## **Boston Alternative Energy Facility**

Schedule of changes to the Draft Development Consent Order

Document Reference: 9.20

Date: 19 October 2021

Key	
	Order limits
	Land outside Order limits
	Slope Protection
	Public Right of Way
	EXISTING VEGETATION (Existing vegetation within site to be enhanced)
PROPOSED FEATURES:	
	NATIVE SPECIES WOODLAND
	SCATTERED SCRUB PLANTING
	INDIVIDUAL TREE / HEDGEROW TREE PLANTING
	SPECIES RICH GRASSLAND

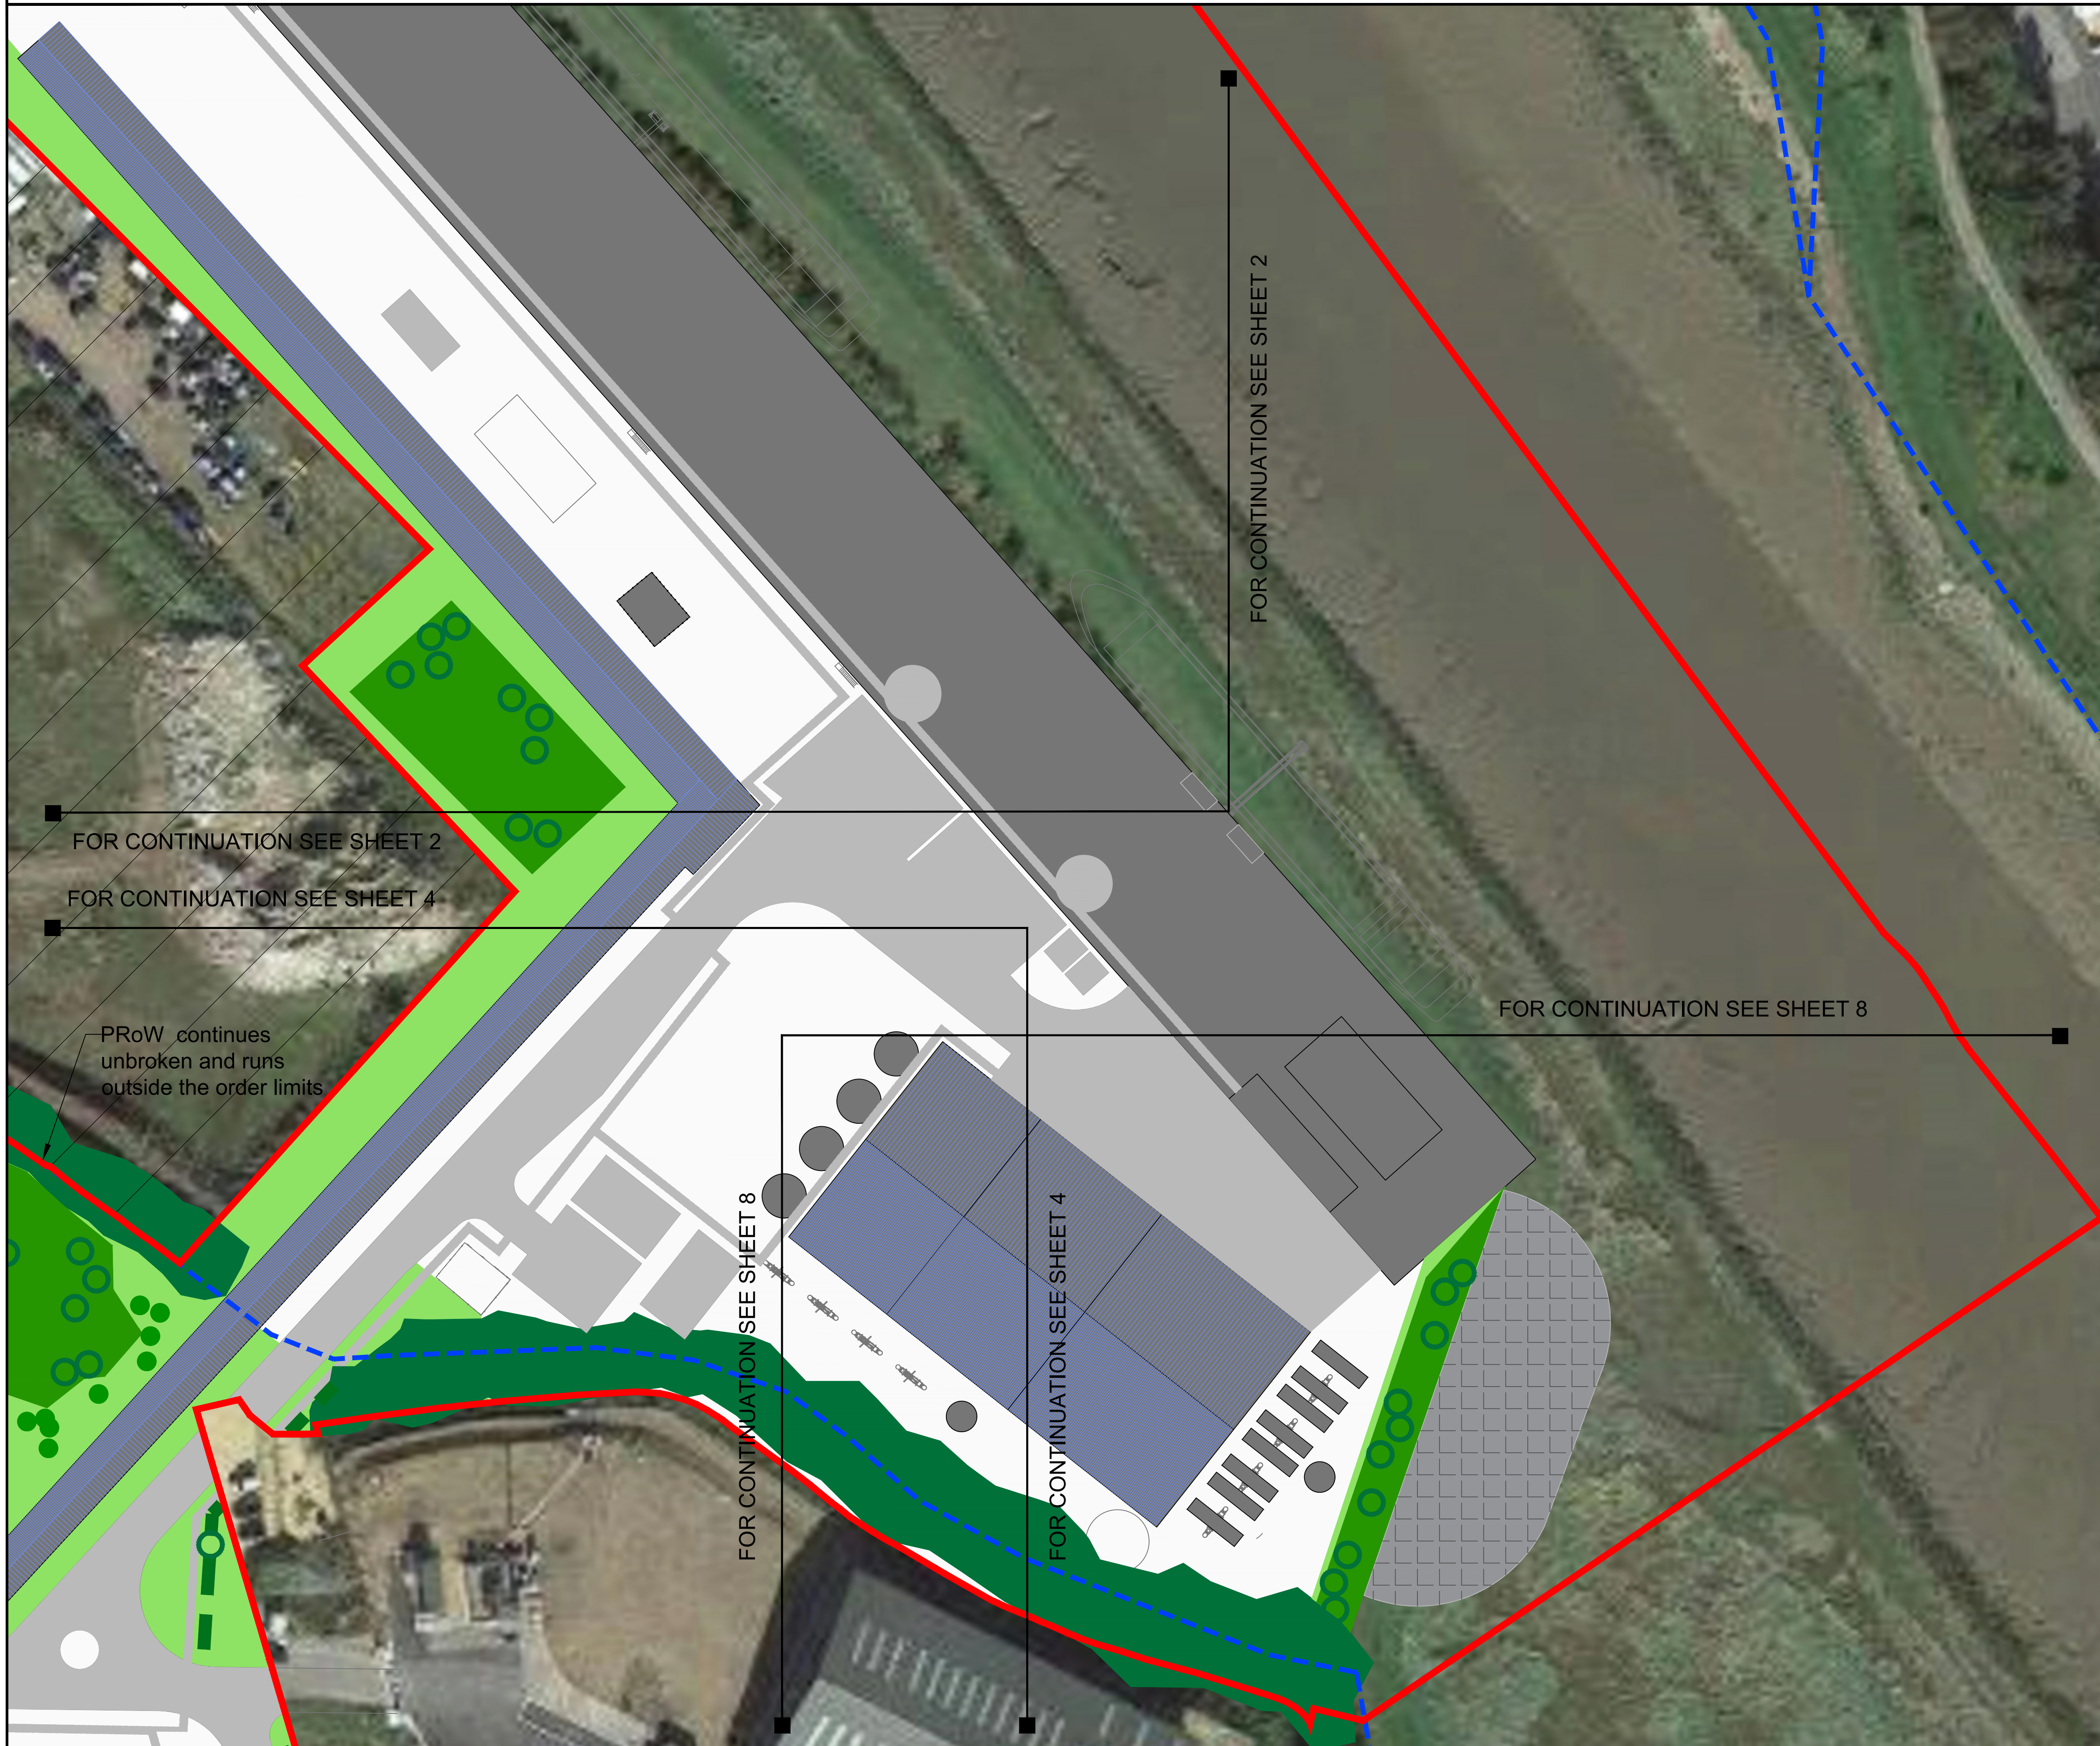
No.	Provision	Suggested amendment	Explanation for change
			Offshore Wind Farm Order 2020.
21.	Schedule 1, Work No. 6, Requirement (d)	(d) a footbridge spanning <del>footpaths BOST/14/11 and BOST/14/9 along the Roman Bank</del> to allow safe pedestrian passage over certain site roads; and	Correction to refer to footpath numbers
